CITY OF PORTLAND

January 22, 2001

Re: 10 Dana St. (032 V001)

This office has reviewed your request for the acceptance of the existing 7' ceiling height, with 8 locations where the height is as low as 6'8", on the first floor, at the above location. The following are finding of fact with regard to the above review:

FIRST FLOOR PLAN

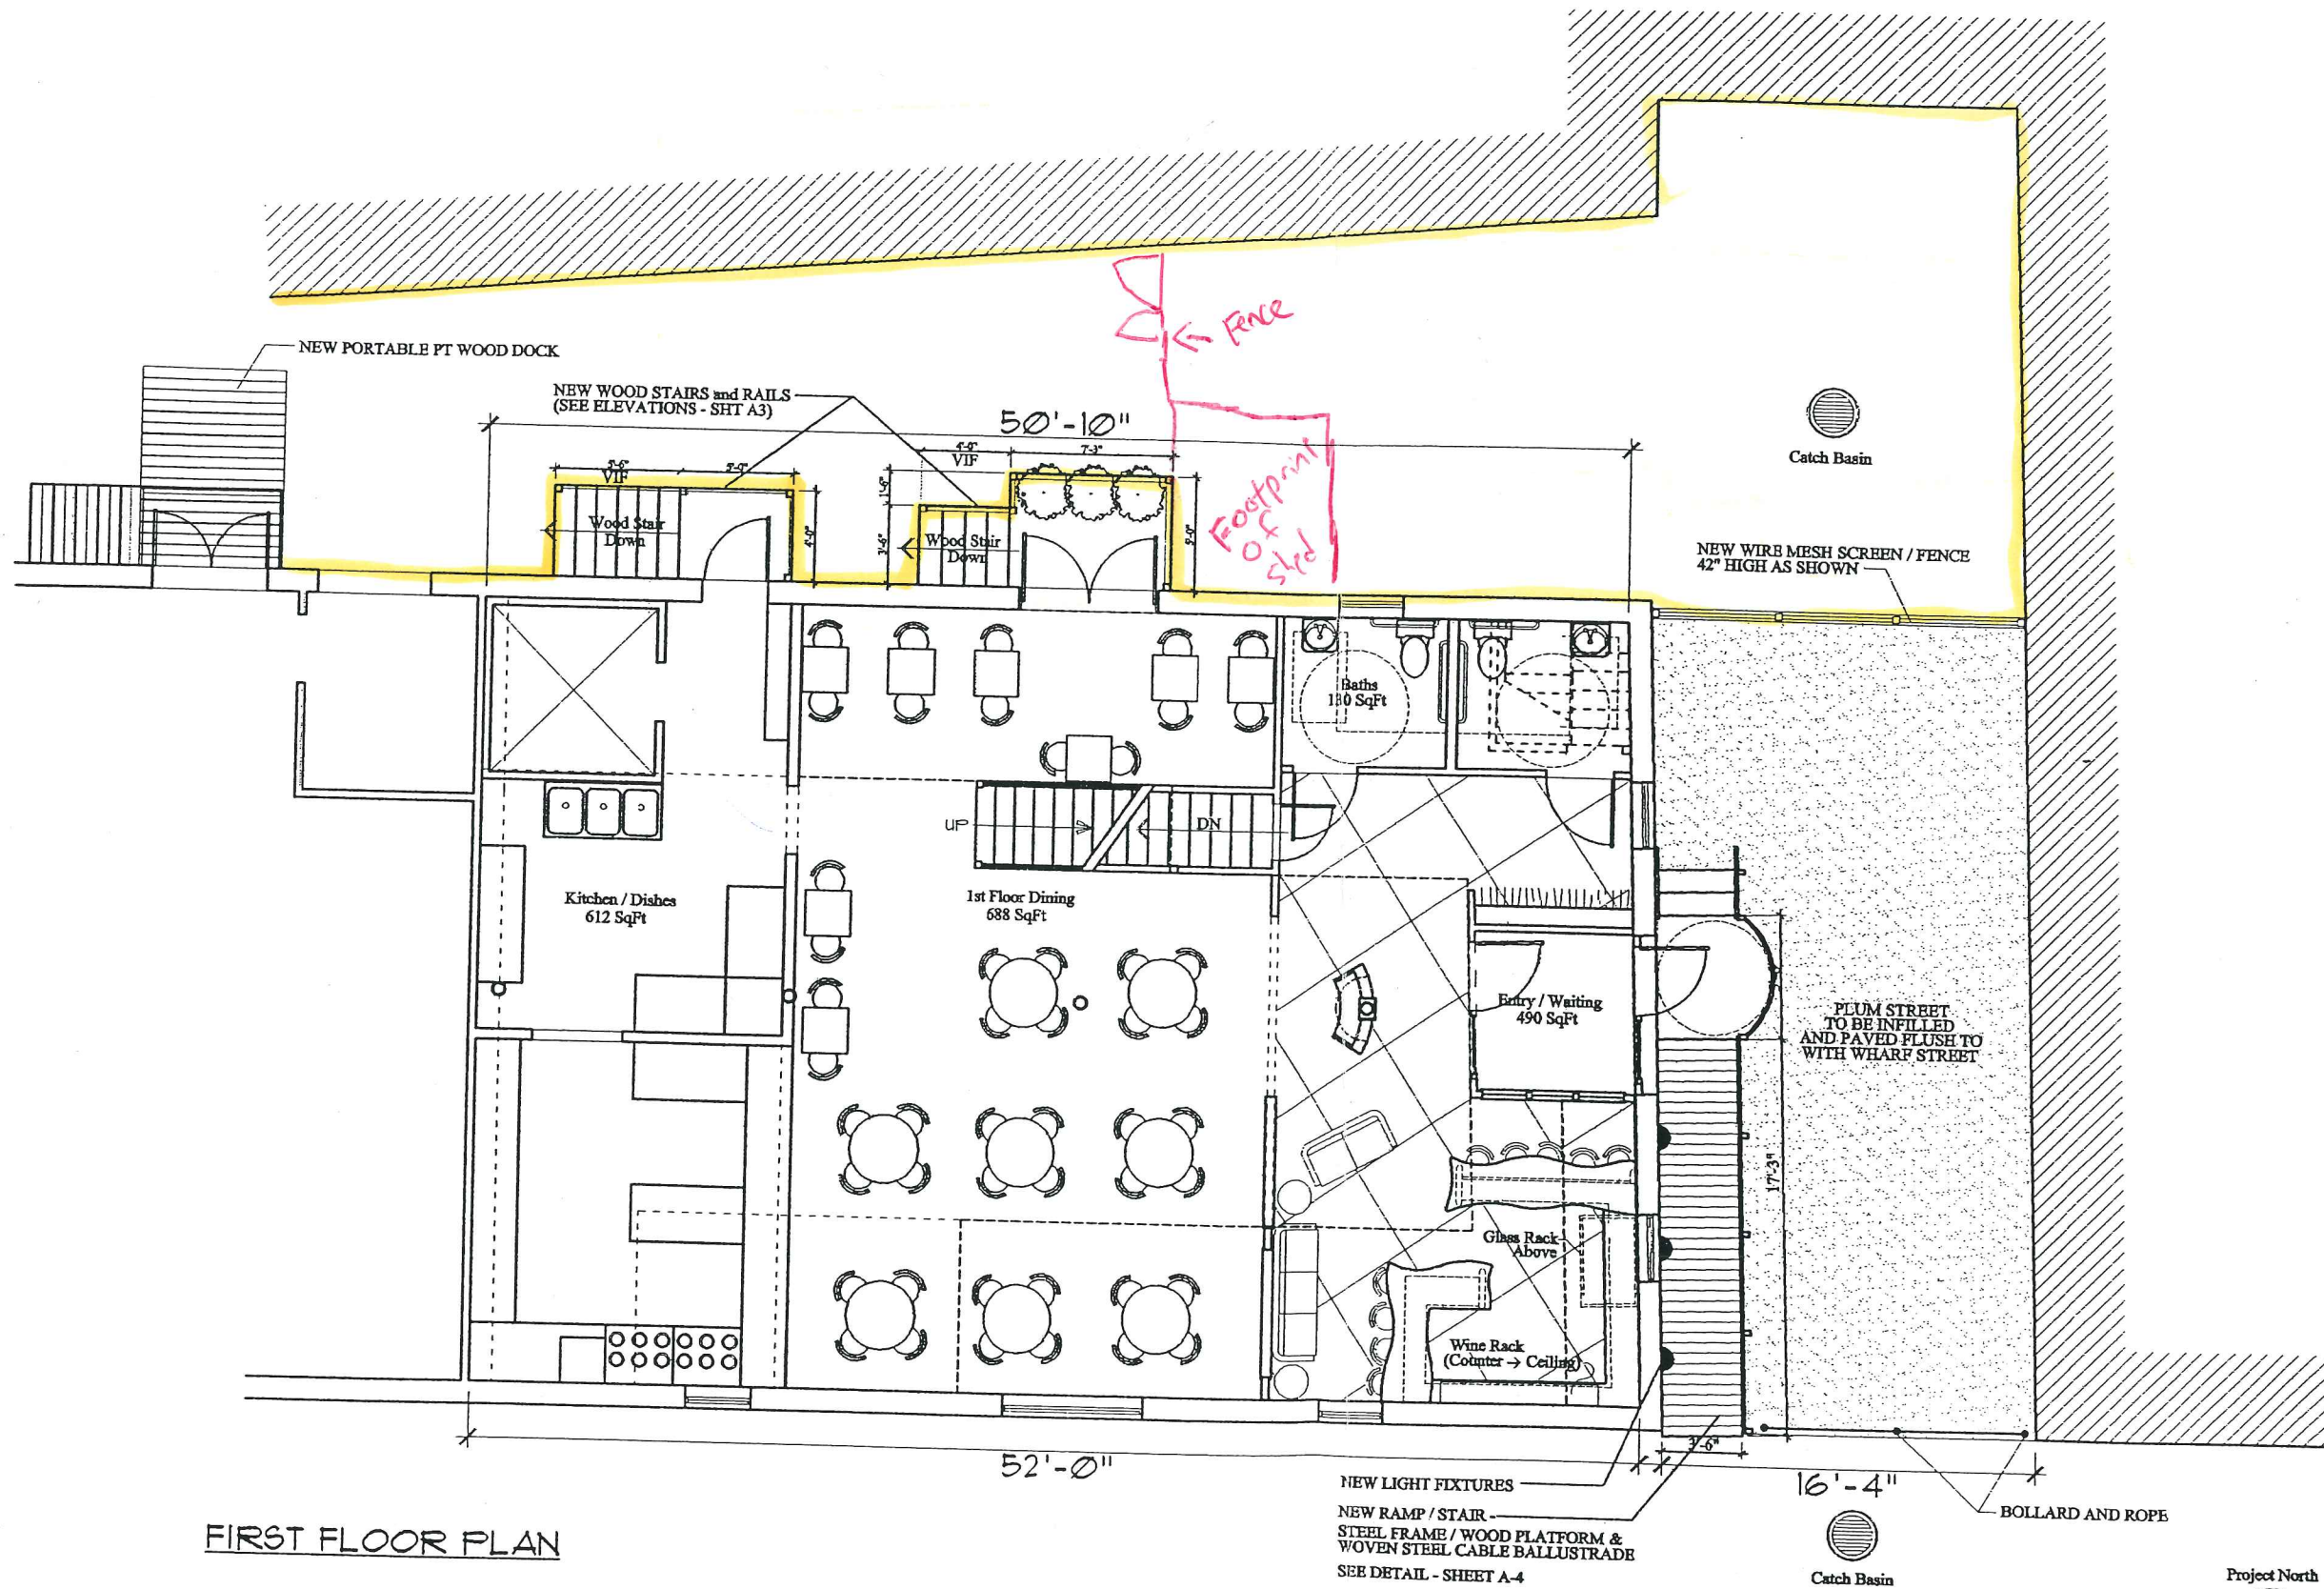
- 1) This property is in the process of conversion from a Storage Use Group to an Assembly Use Group.
- 2) The condition is existing and has been present since the building was constructed.
- 3) The proposal will comply with all other applicable provisions of the Building Code, as they apply to this change of use.
- 4) The building is located in an Historic District.
- 5) The required ceiling height is 7'6" for this use group.

Because of the above facts, and pursuant to the authority of Section 3406. of the City of Portland Building Code (1999 BOCA), the above condition can remain as built. The Code states that the provisions of this Code shall not be mandatory for existing building and structures identified and classified by federal, state or local government authority as historic buildings, where such building are judges to be safe and in the interest of public health, safety and welfare. Please feel free to contact me if you have questions at 874-8700.
